ENG-CDR20004-R3-FDR.pdf Markup Summary

Engineering Review
12/14/2021 2:32:06 PM
dsdrice
dsdrice@epcd.com
(719) 520-7877
EPC Planning & Community
Development Department

for Sand Creek Restoration

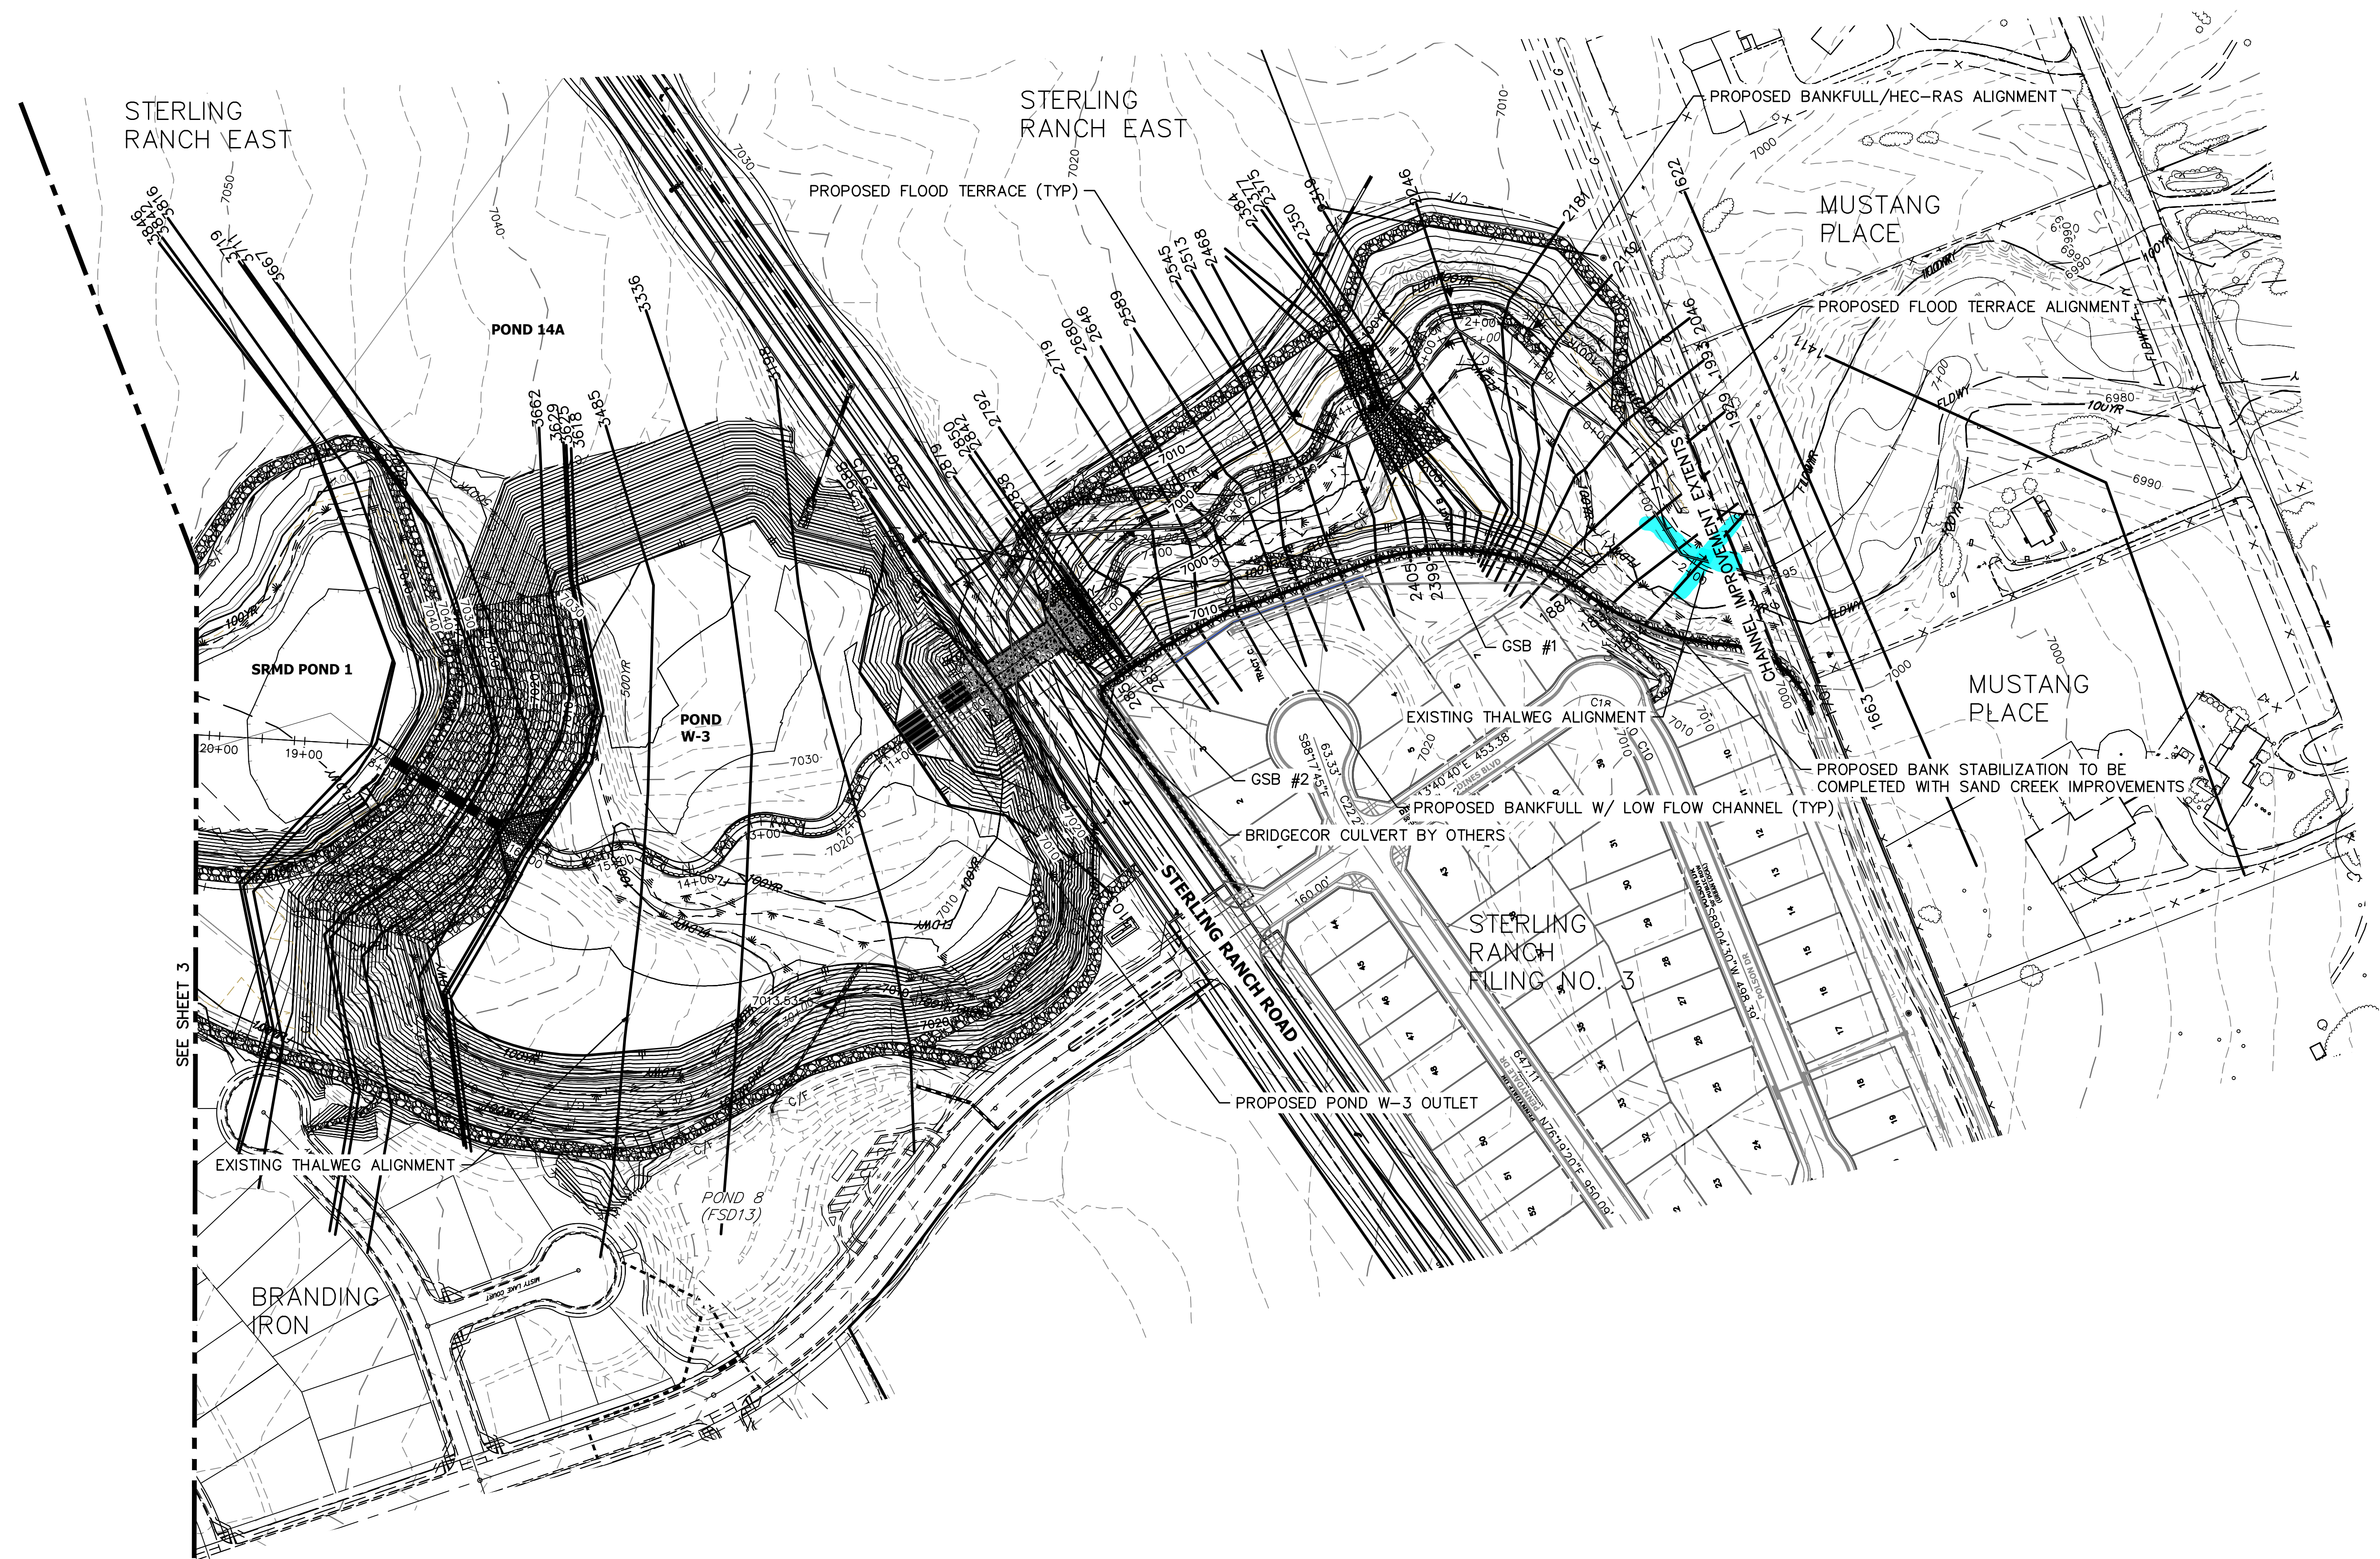
Add wetlands mitigation plan
